PRE-APPLICATION ENQUIRY DC/20/04905

Southolt Hall Noth Barns, Southolt Hall, Southolt Road, Southolt Eye Suffolk

Pre-application Enquiry

Conversion of heritage barn to dwelling. Erection of 4 bay cart lodge with loft over to north of barns.

DRAWING
 Proposed Access

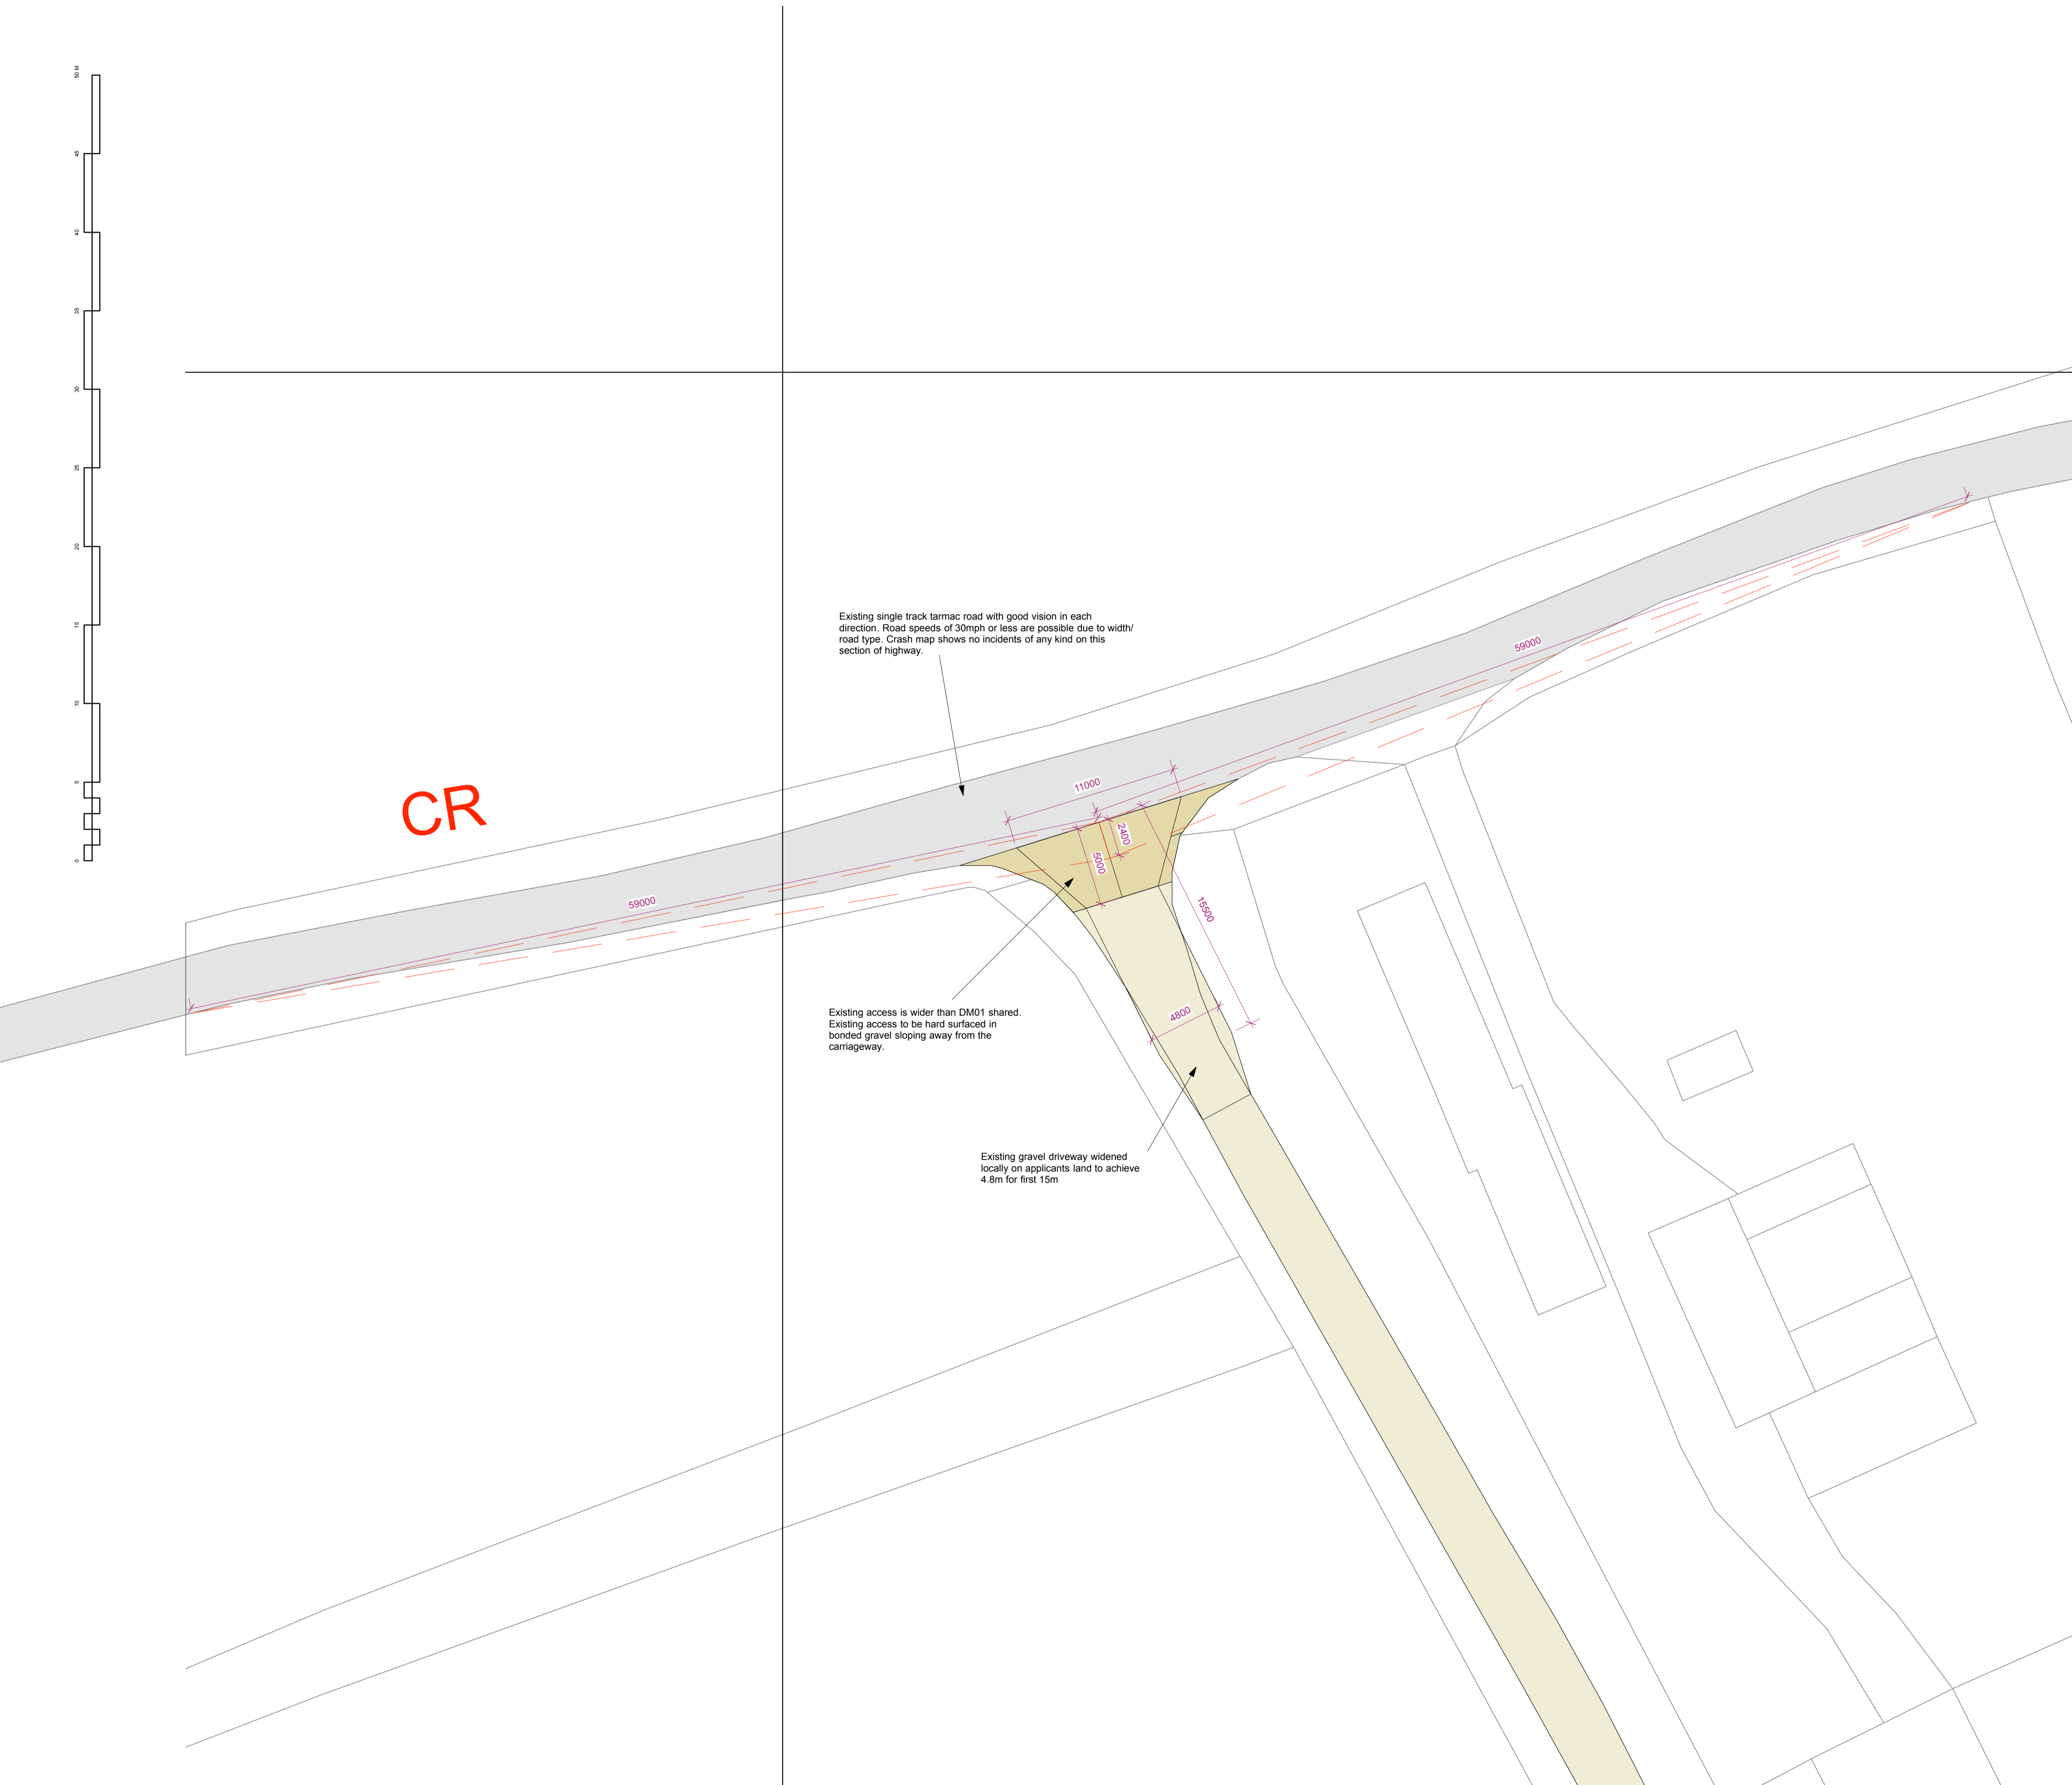
The enquiry submission proposed to create a new access from the existing farm track which joins Southolt Road to the north. In respect of Policy T09 and T10 and Paragraph 109 of the NPPF, development should not adversely affect the highway network and associated safety.

The Highways Authority will be consulted on any future application where the impact on the highway will be assessed. An assessment would be made regarding the intensification of the farm track. The proposal will need to ensure that the parking provision from the proposed dwelling is met, in accordance with the parking standards set out within SCC Guidance for Parking. (<https://www.suffolk.gov.uk/assets/planning-waste-and-environment/planning-and-development-advice/Suffolk-Guidance-for-Parking-2019-Adopted-by-SCC.pdf>).

The application submission will need to demonstrate that the visibility splays and on-site parking requirements can be met. The Highways Authority will be consulted on any future application where the impact on the highway network and safety will be assessed. Should an objection be raised in this respect, this would be sufficient to warrant refusal of the application.

SITE PLAN
 1:200 scale

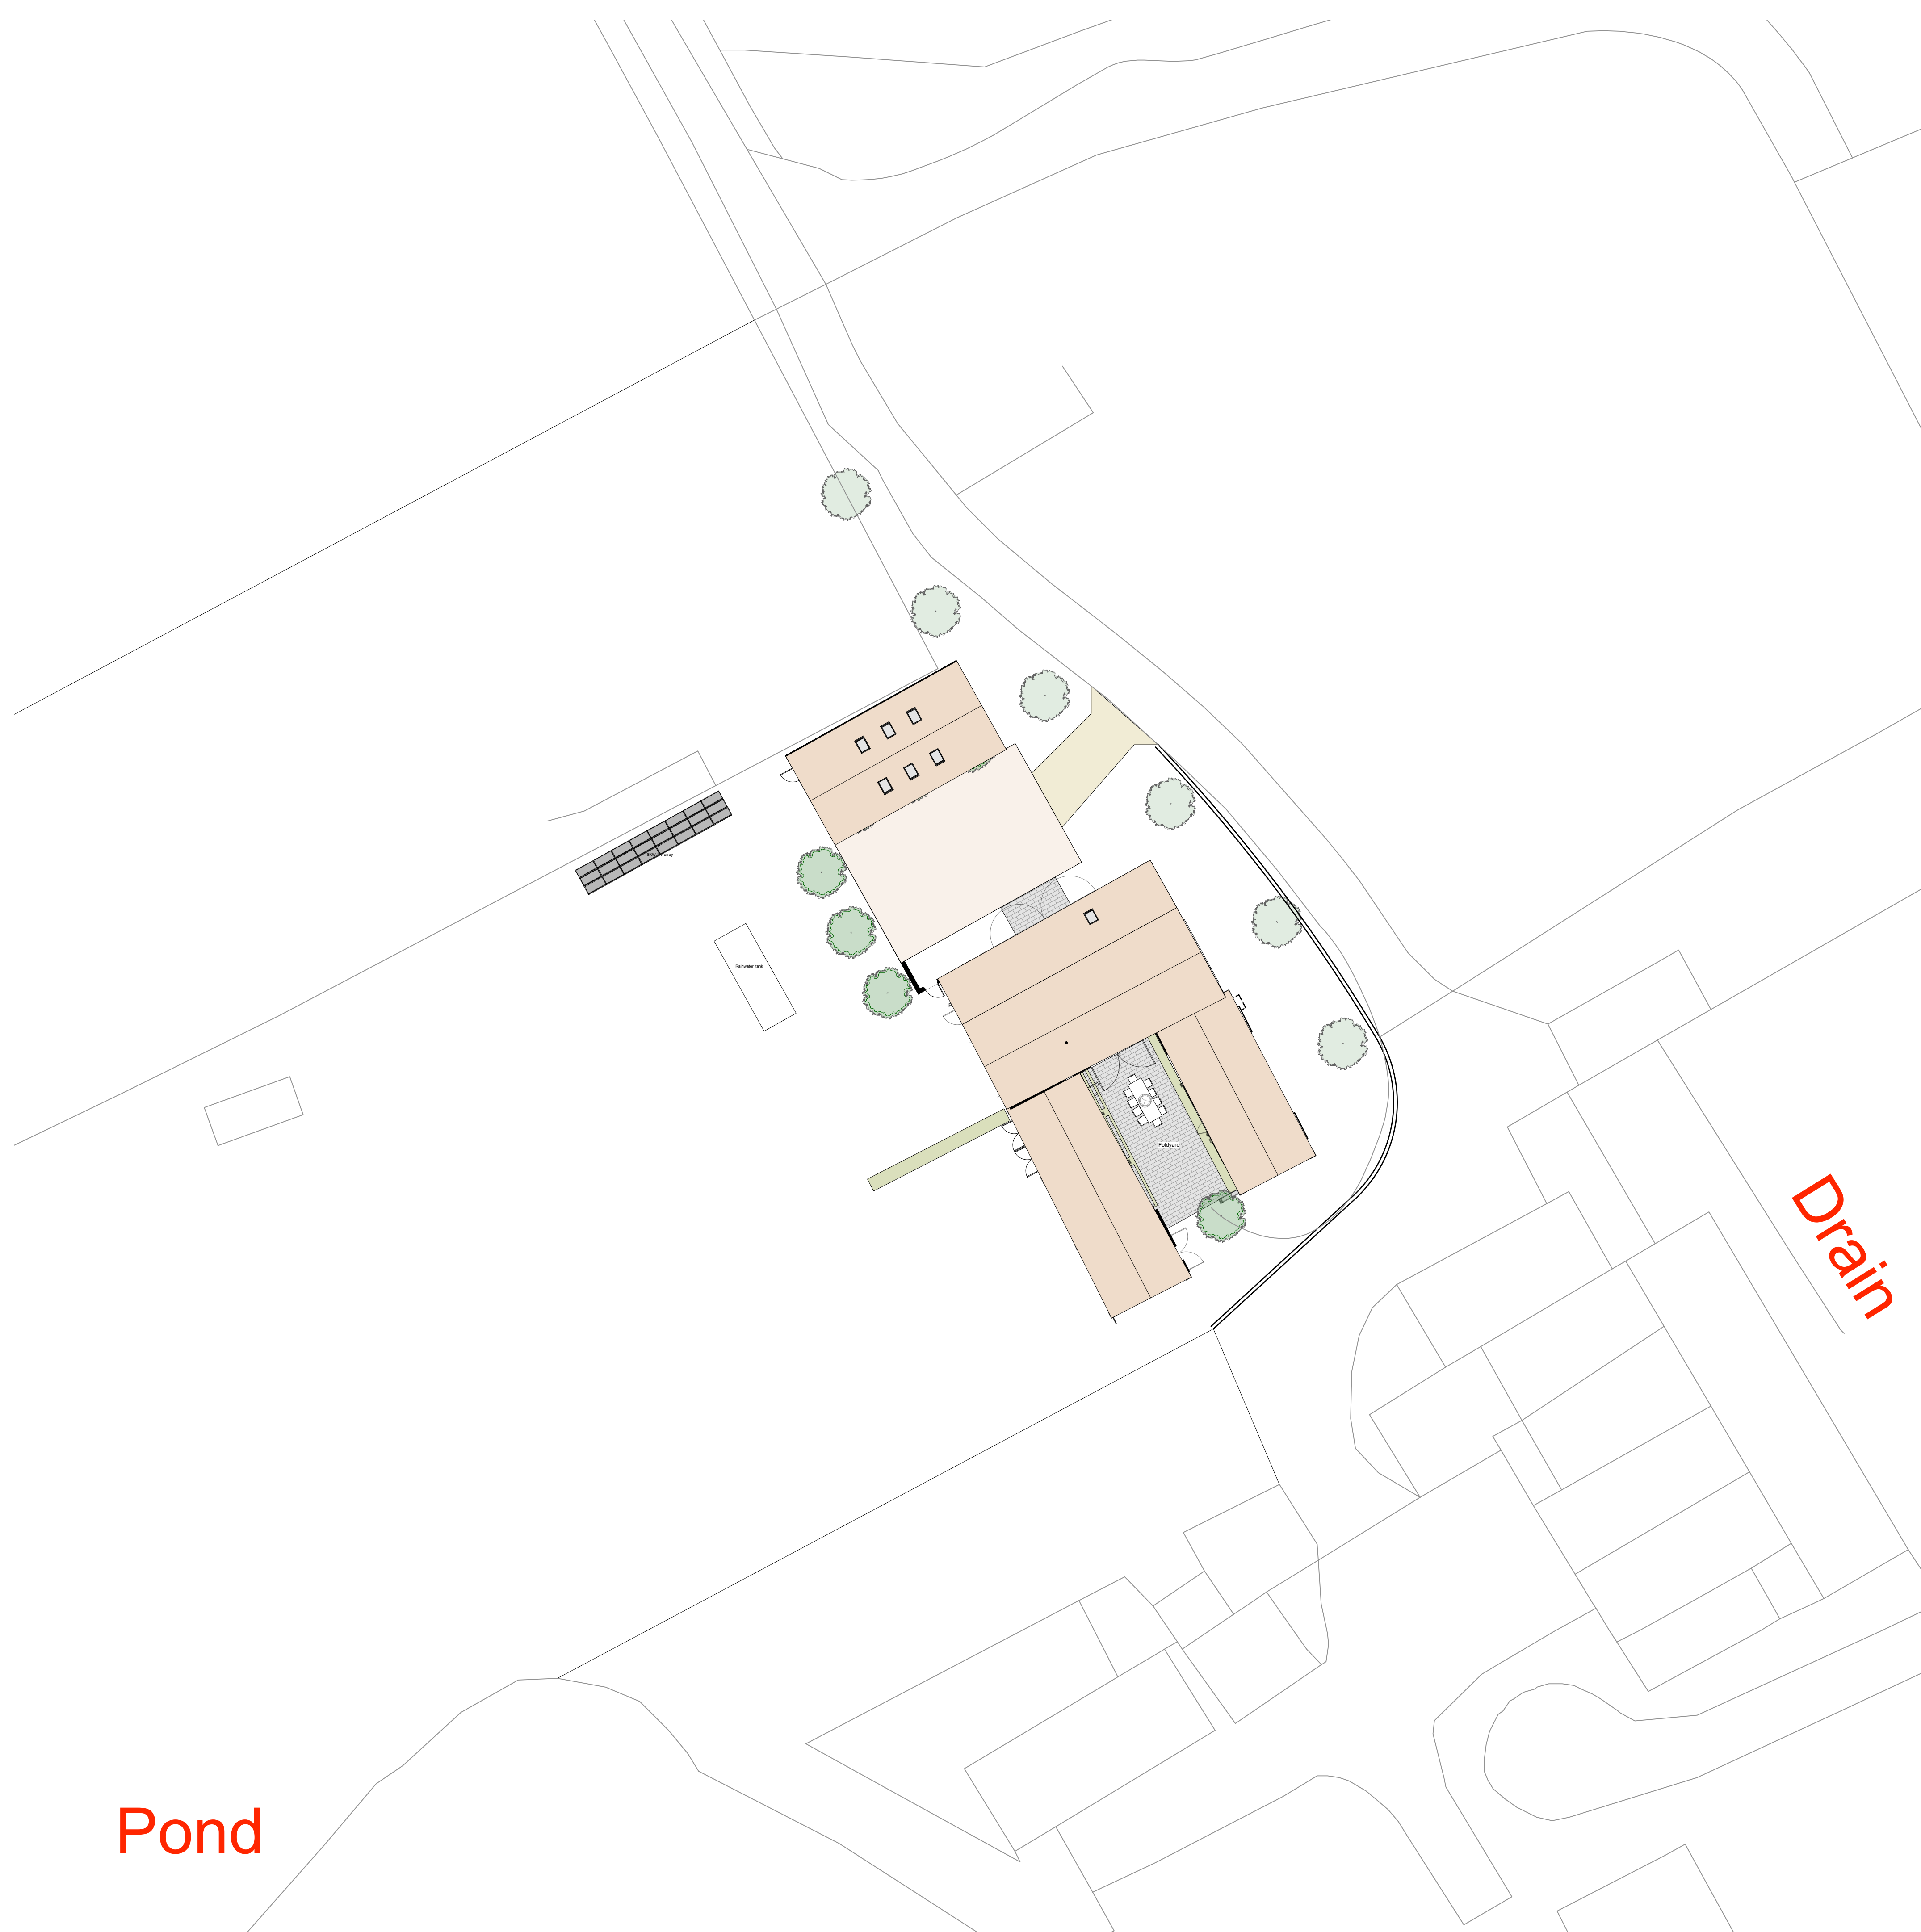
The proposed site plan illustrates the area for outside amenity space and soft and hard landscaping. In compliance with Local Plan Policy H9, the residential curtilage proposed would respect the existing boundaries and maintain the character of the area. The Heritage Officer requests that any future application indicates the proposed boundary treatments for consideration.

PLAN

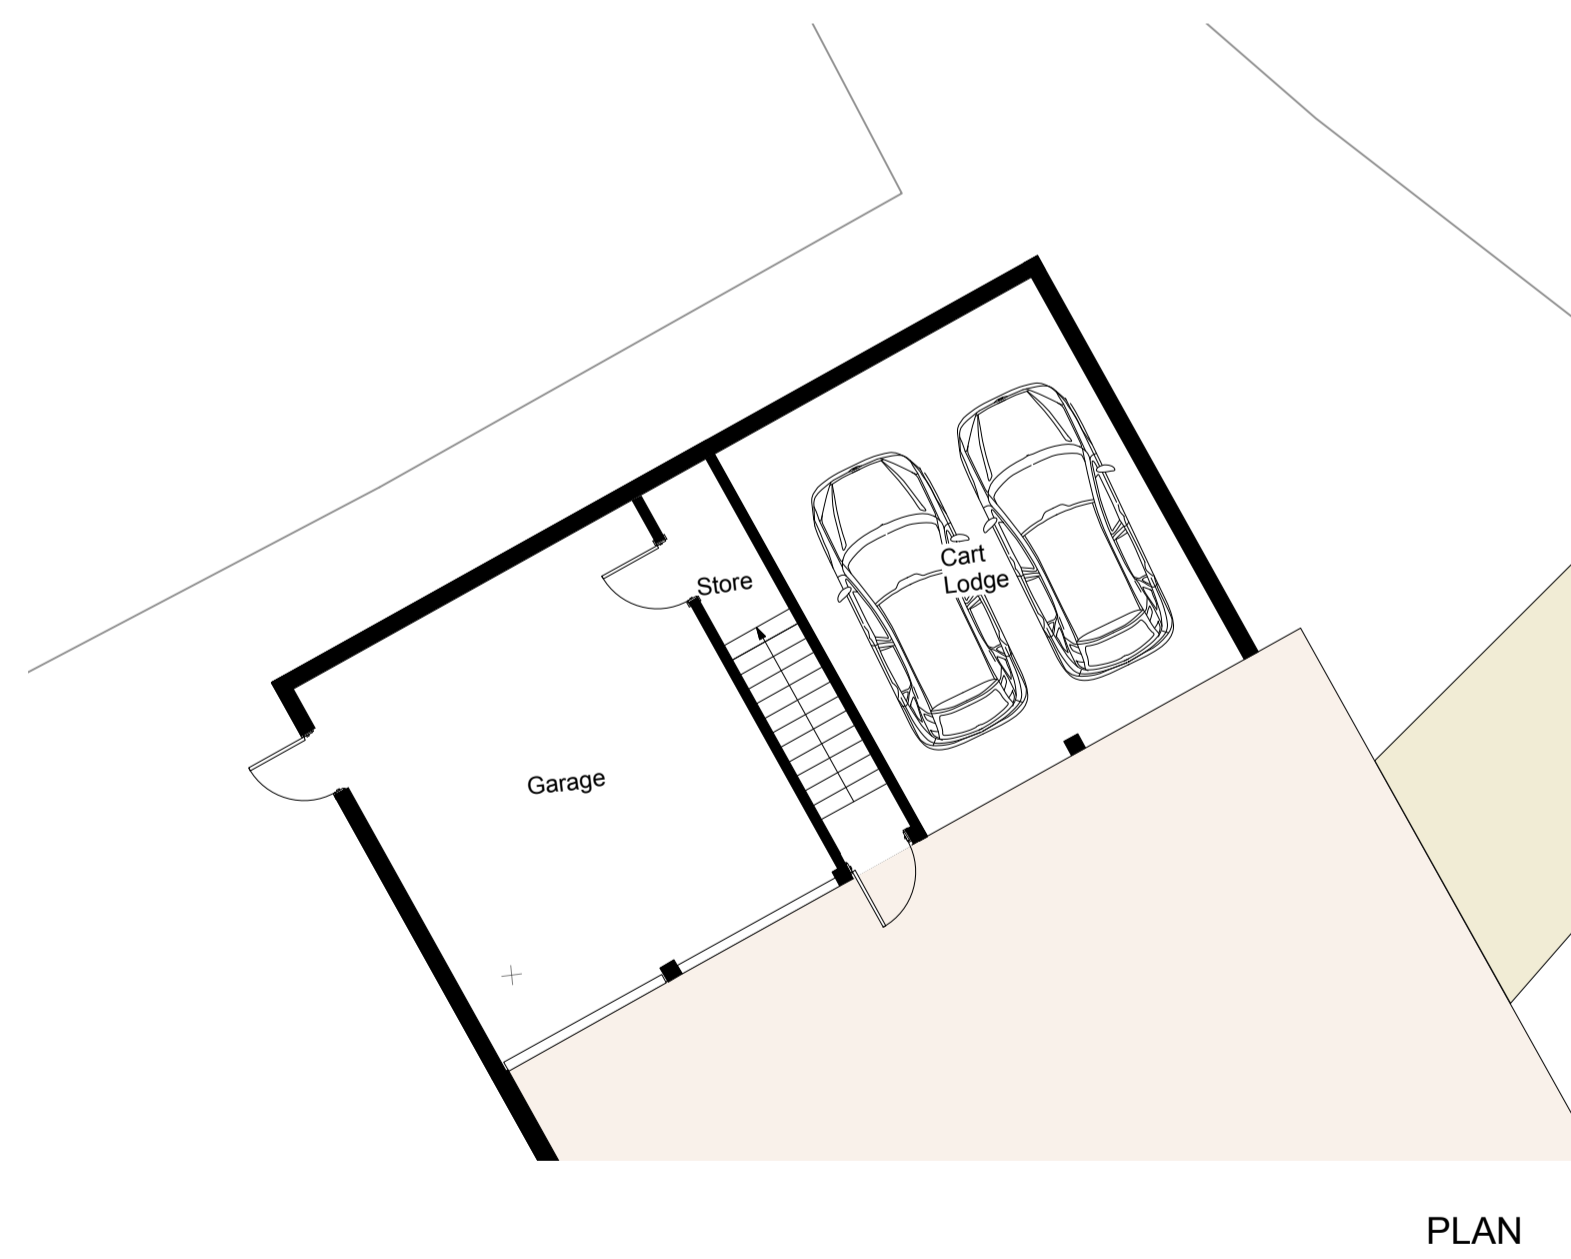
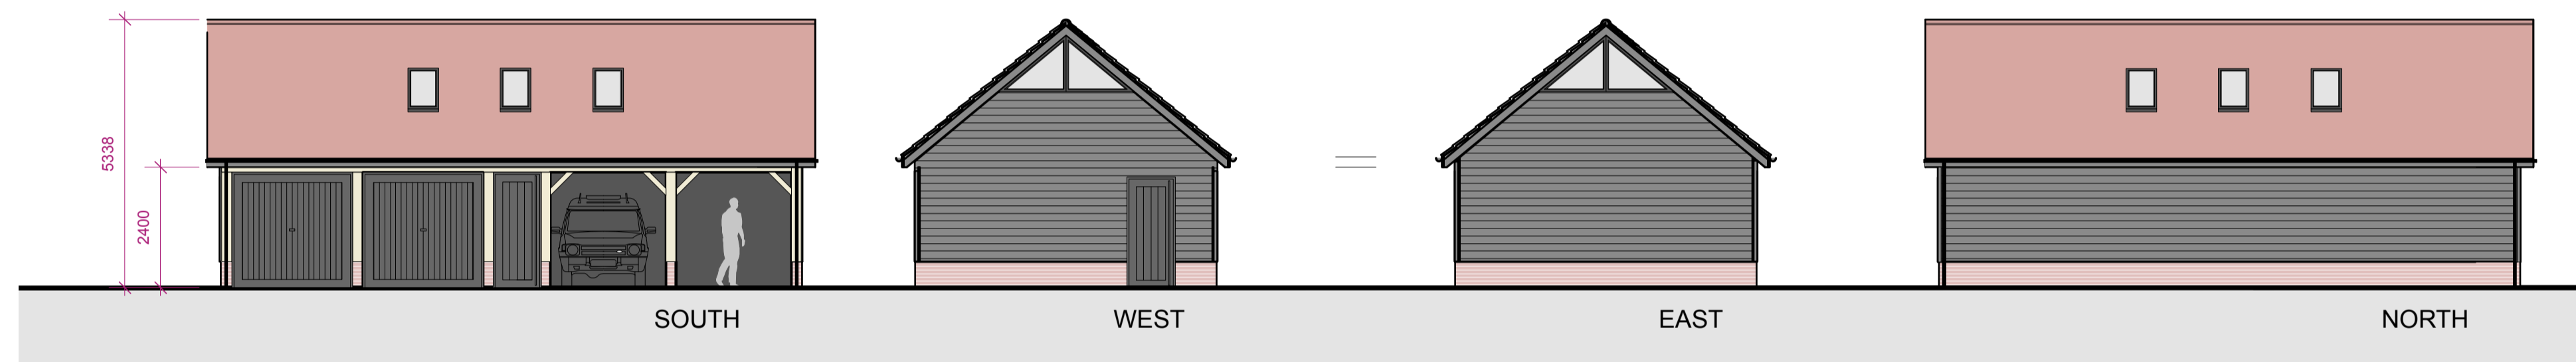
The proposed cart lodge would measure approximately 11.6m x 6m. It would have a pitched roof with a ridge height of 5.1m and an eaves height of 2.2m. The proposed cart lodge would comprise of four bays, two of which are open, and a store above. It is considered that the proposed cart lodge is in keeping with the scale and design of the barn.
